Please find below comments from Private Sector Housing in relation to the above Planning Consultation:

Subject: Planning Consultation on: BR/86/20/PL

Site Address: Aldwick House Care Home 41-45 Nyewood Lane Bognor Regis
PO21 2SJ

Description of Works: Part change of use from a 32-bed nursing home (C2 Residential Institutions) to a 38-bedsit House in Multiple Occupation (sui generis) comprising 24 No single person & 14 No two-person bedsits along with separate shower rooms & wcs, demolition of rear conservatory & store & erection of single storey rear extension & with minor external alterations to side elevations & insertion of 4 No roof lights on rear elevation, This application is not CIL Liable.

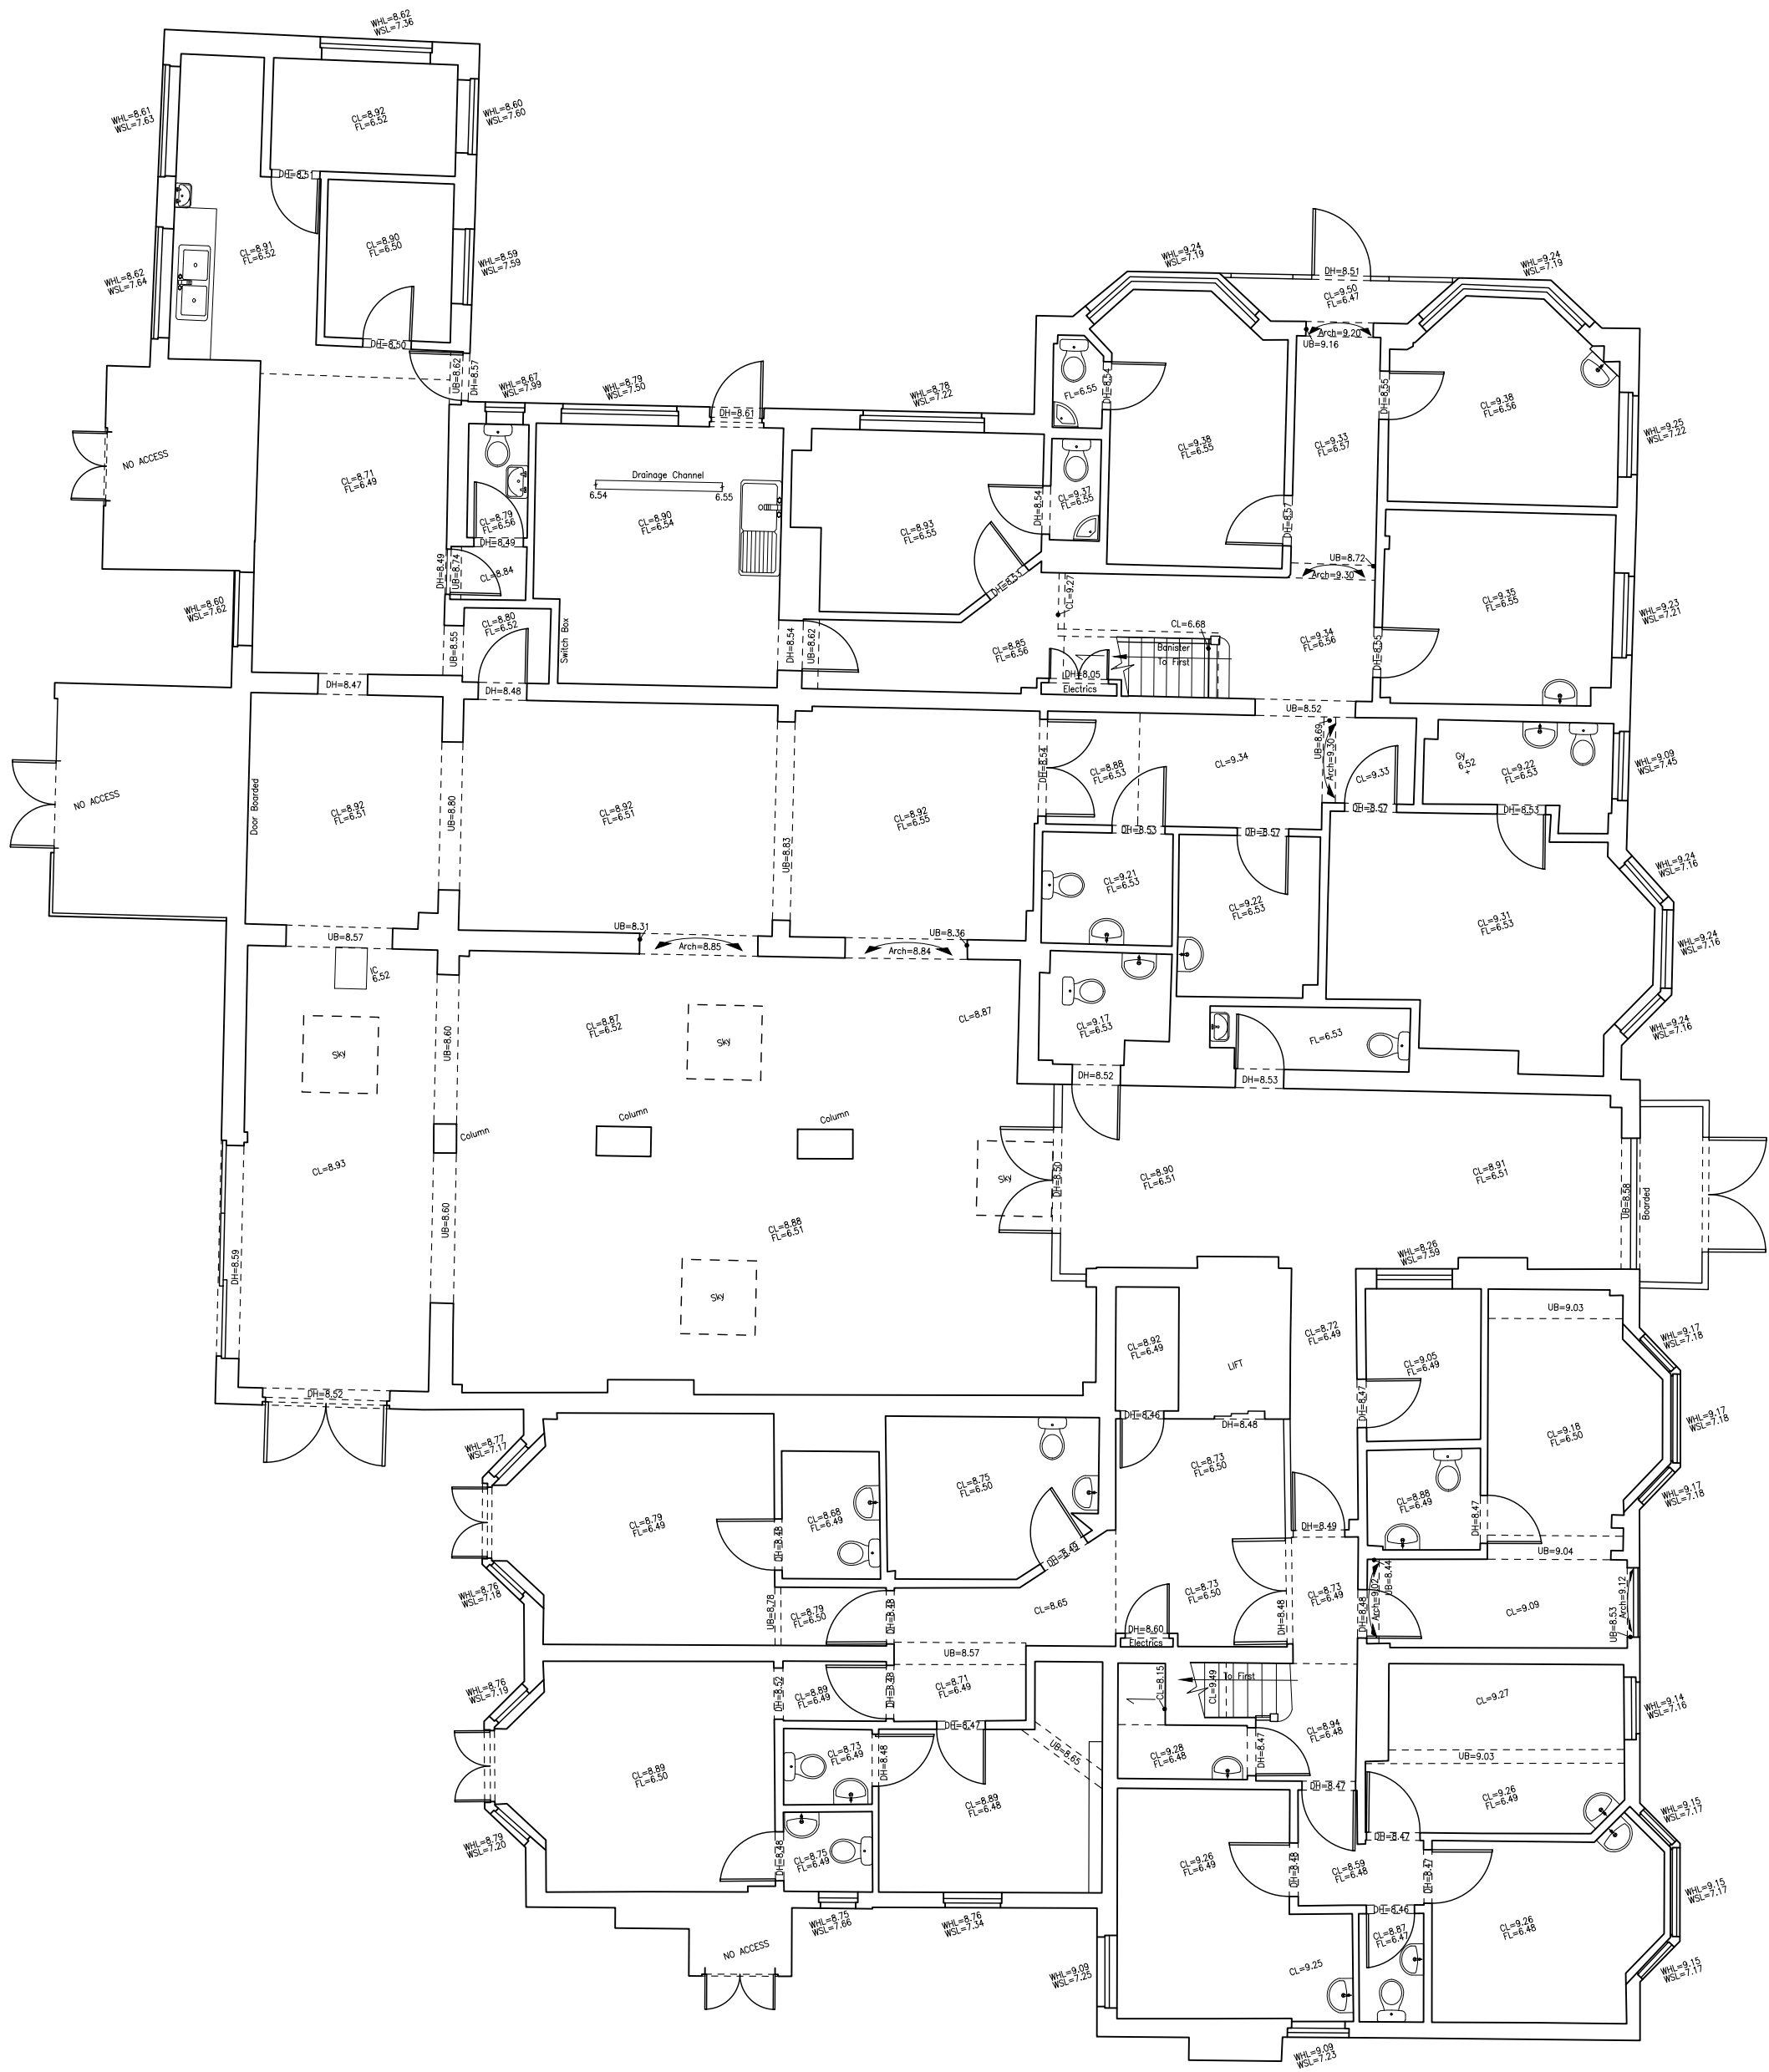
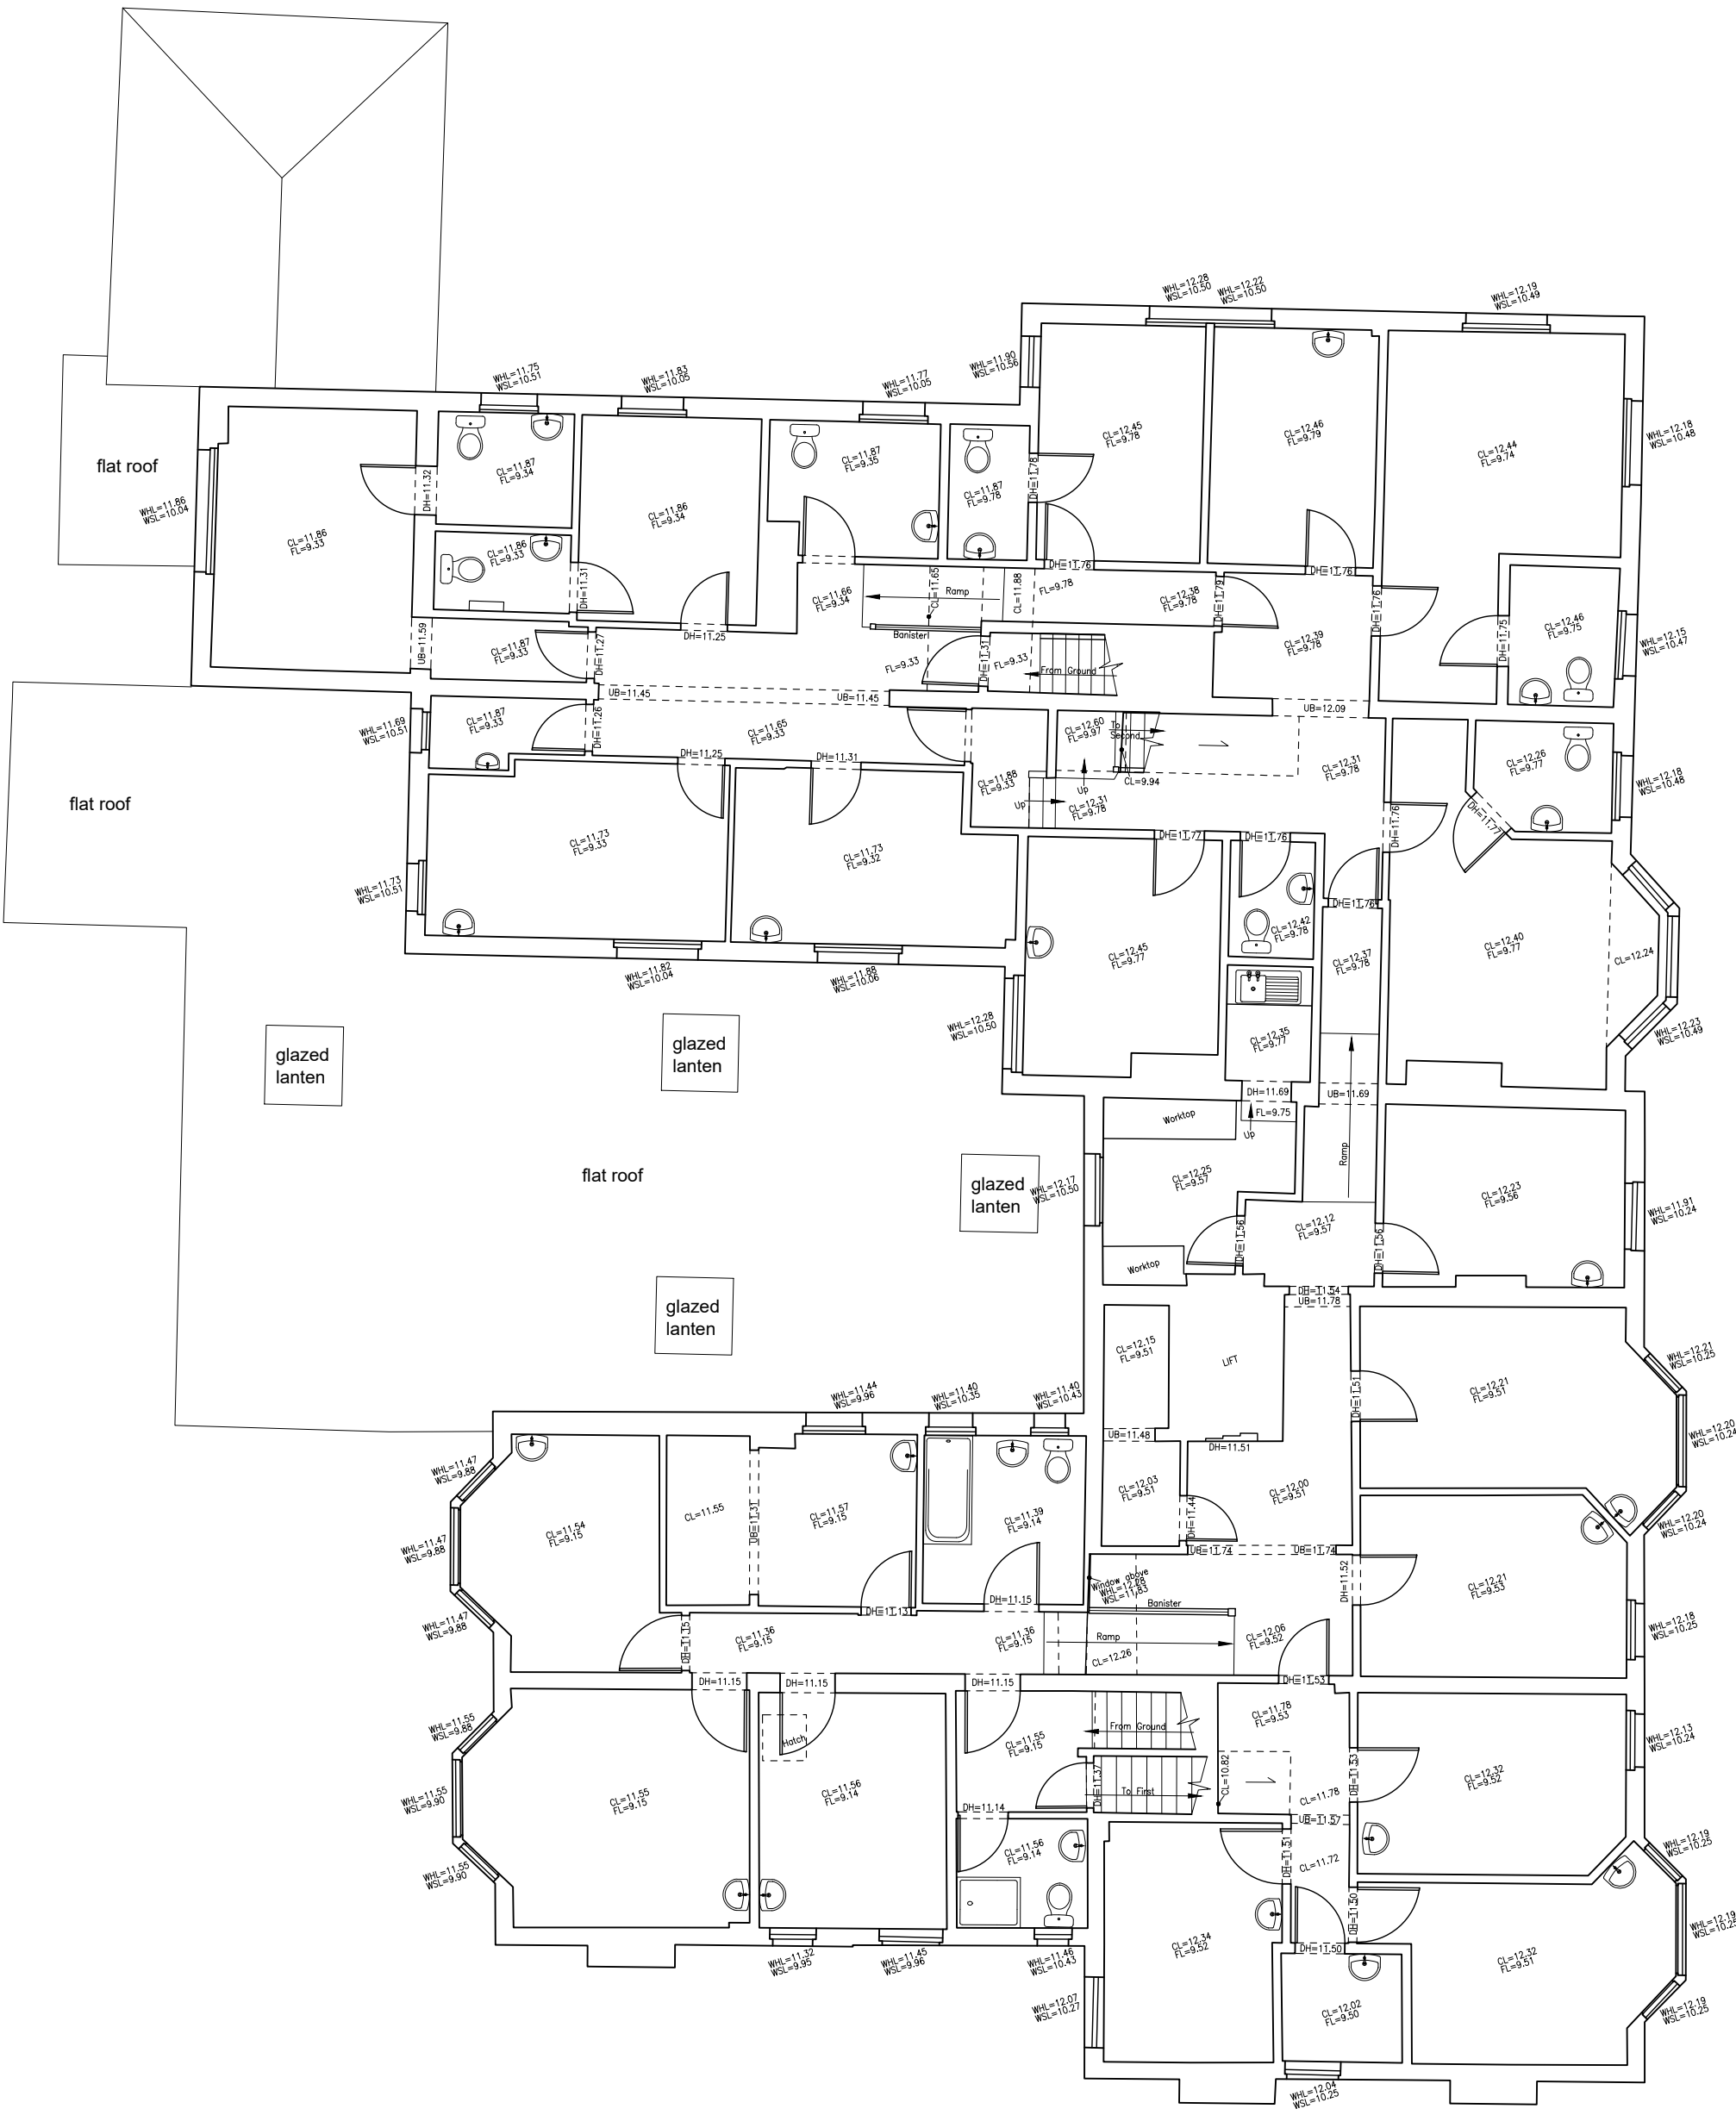
- 30min fire resisting protected escape route is required, which would include 30 minute fire resisting construction and FD30S doors to all risk rooms.

SECOND FLOOR / ROOF PLAN

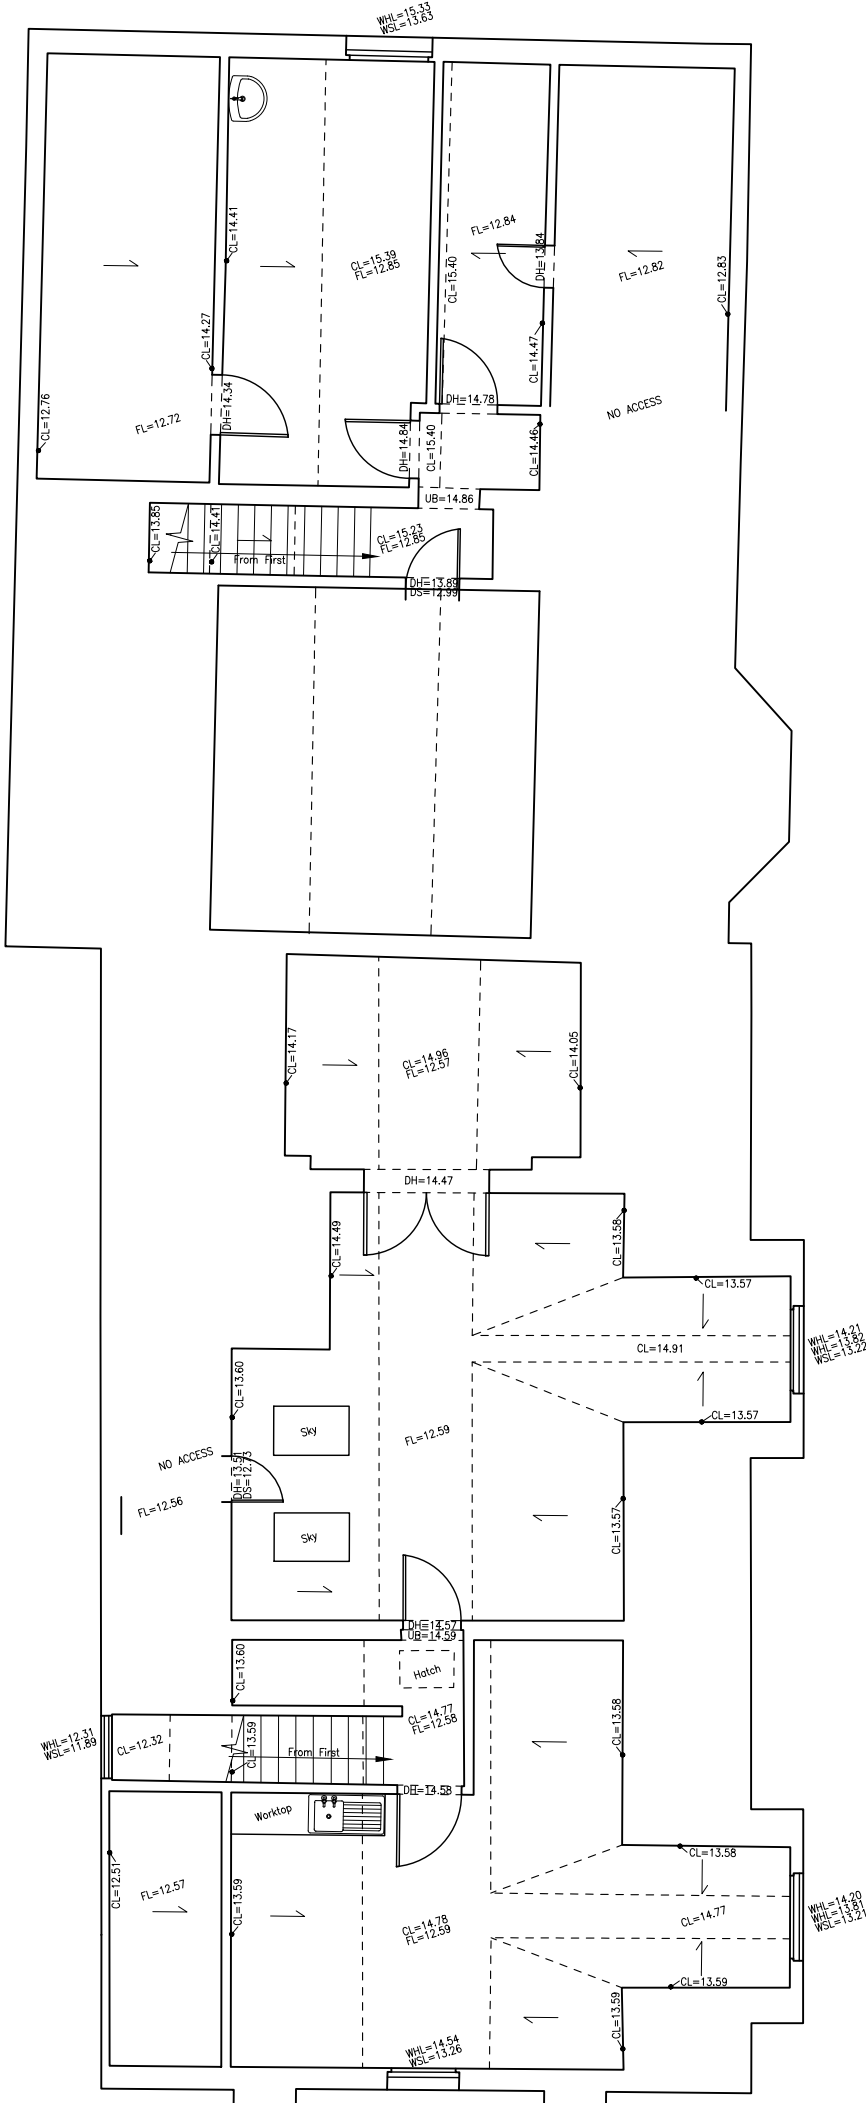
- From the plans, it could not be determined if sufficient natural lighting would be available in rooms 36, 37 & 38. Room 38 does not appear to have any windows with a view proposed, only roof lights. **This is not considered acceptable.** Velux windows or ceiling/ roof casements as the only source of light, ventilation and view should be avoided where possible. If the roof lights are the sole source of light and ventilation, alternative windows will be required to be installed and may be included within stipulated conditions on the HMO Licence..
